Your Ref: OWPC19725
Our Ref: A/83/18/RES
Please ask for:
Mr D Easton

22nd August 2018

Approval of reserved matters following outline approval A/44/17/OUT for access only for the demolition of existing buildings on site & the erection of a mixed use development comprising up to 90 No. residential units & a care home (Use Class C2 & C3) & ancillary facilities, including railway crossing, together with associated access, car parking & landscaping. This application also lies within the parishes of Littlehampton & Rustington.
Land west of Brook Lane and south of A259 Rustington

drawing number SPRUST(BROOK LANE).1/10 rev. D

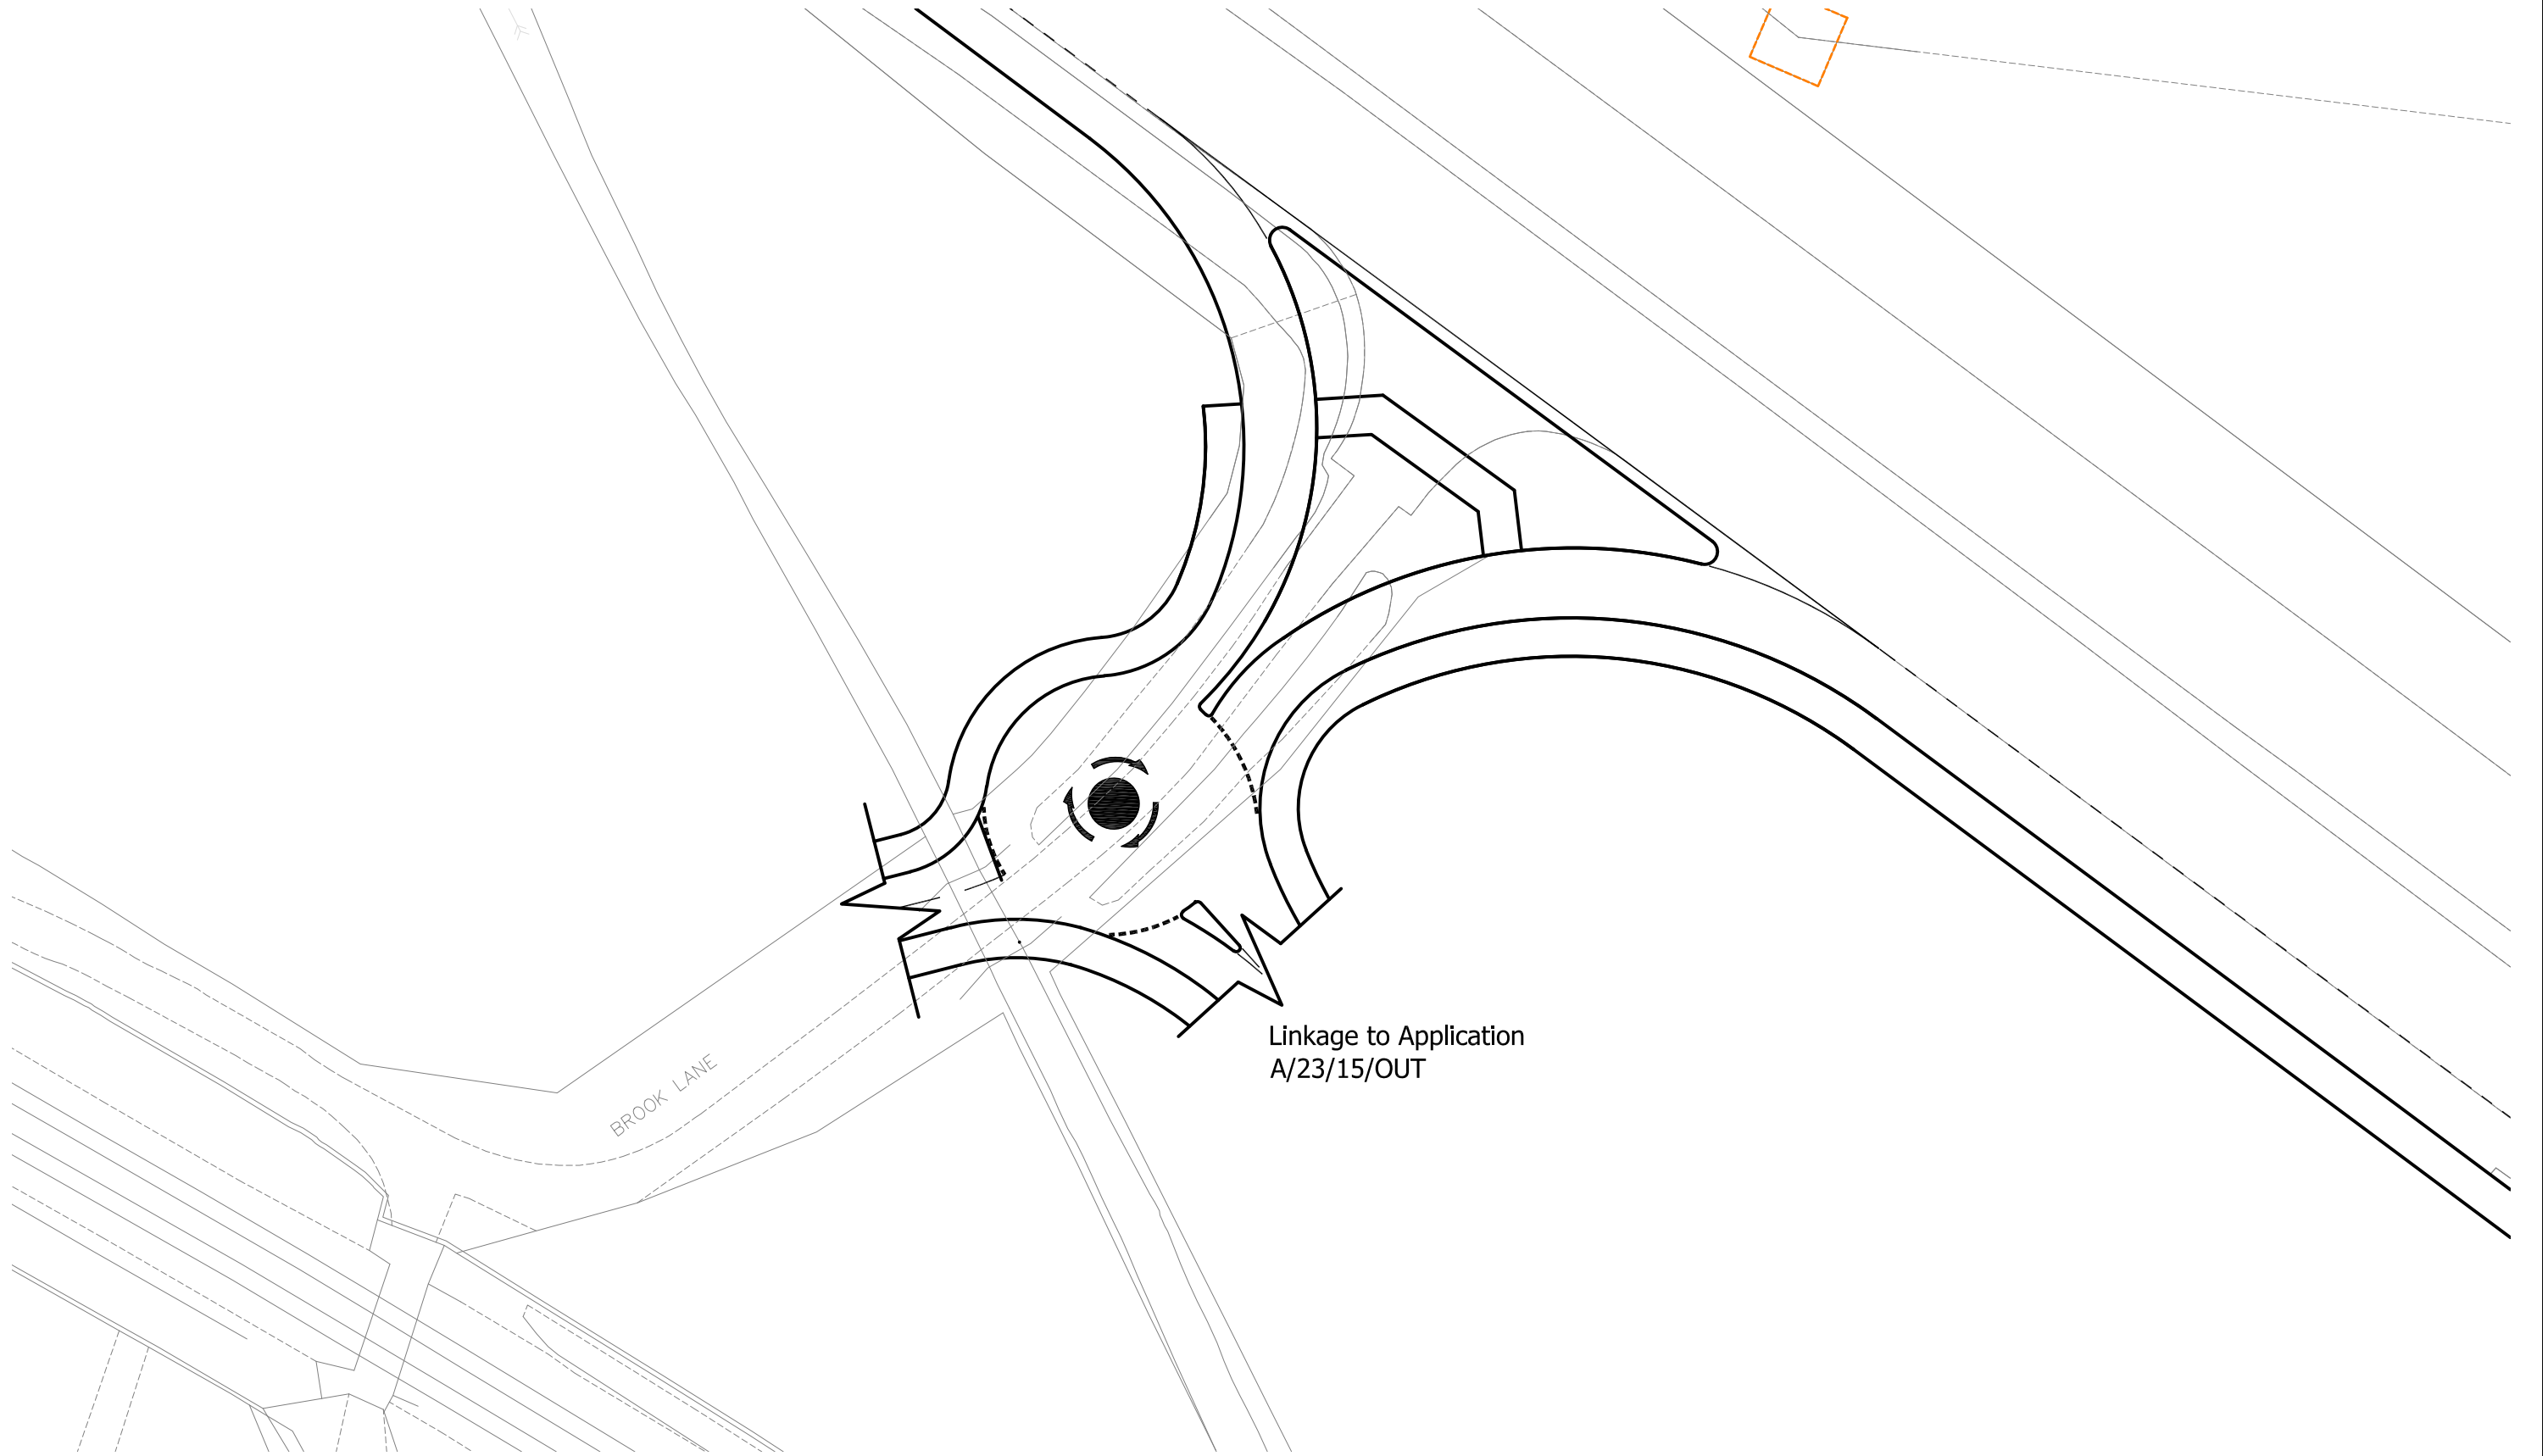
The Town Council's Planning and Transportation Committee considered this matter at its meeting held on Monday 20th August 2018 and commented further as follows: Whilst the proposed roundabout would provide a means of connecting the site with the proposed adjacent retail development, the application did not demonstrate that it was capable of meeting the need. It was noted that clarification on this point via a further Road Traffic Audit would satisfy this requirement.
